Date: 26-May-2026
Our Ref: 2026/91176

Application for a non-material amendment following a grant of planning permission, Town and Country Planning Act 1990

**Non material amendment to previous permission 2024/93227 for variation condition 2 (plans) on previous permission 2020/94345 (APP/Z4718/W/21/3289729) for erection of 5 dwellings
land at, St Luke's, Bierley Marsh, East Bierley, BD4 6PL
Application Number: 2026/91176**

client name		Owens Developments Ltd	
project		New Dwellings - Land at St Lukes.	
drawing		House Type A : Terrace North and West Facing Elevations	
project number	19/157	plot date	24/11/20
		scale	1:100
drawing number	105	rev	B
		issue status	Planning Submission

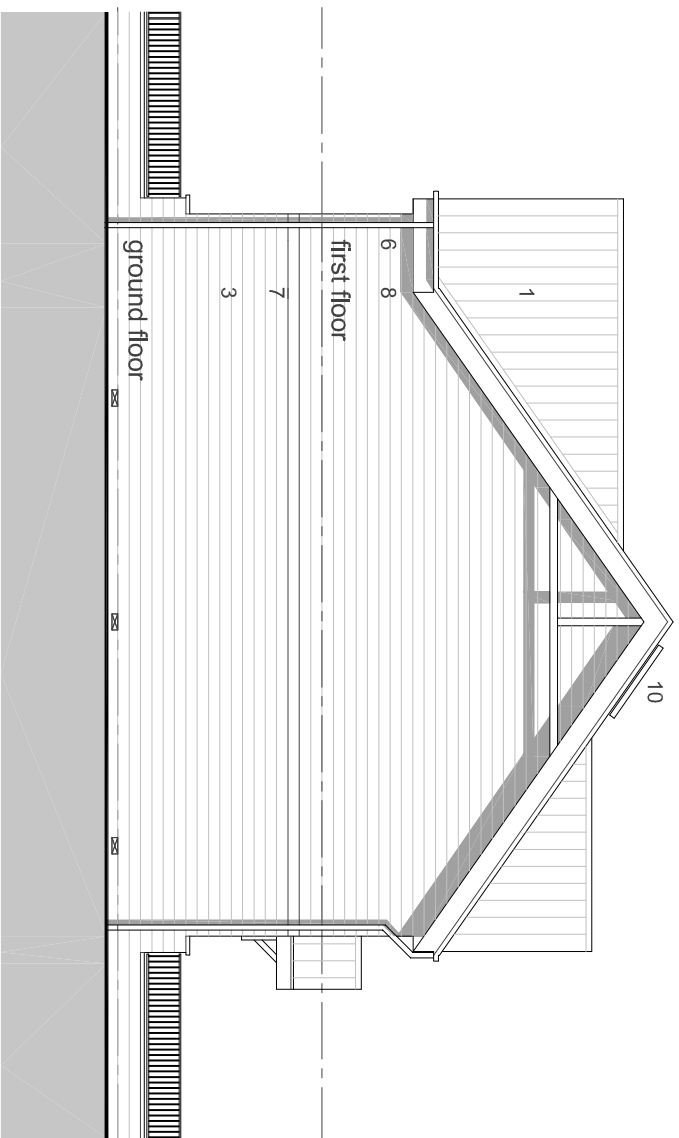
- Addition of solar panels to the roof planes of dwellings

- House type B south and west elevations (DWG: 113 REV:A)
- House type B North and East (DWG: 112 Rev:A)
- House type A Terrace North and West elevations (DWG: 105 REV:B)

Given the above assessment, it is not considered that sufficient details have been provided and that due to the nature of the development, a full assessment would be

required to ensure the proposal would not have a detrimental impact on visual amenity, nor that they would be detrimental to a third party. The amendments are not considered to be in accordance with protocol, and therefore the proposed non-material amendment is refused.
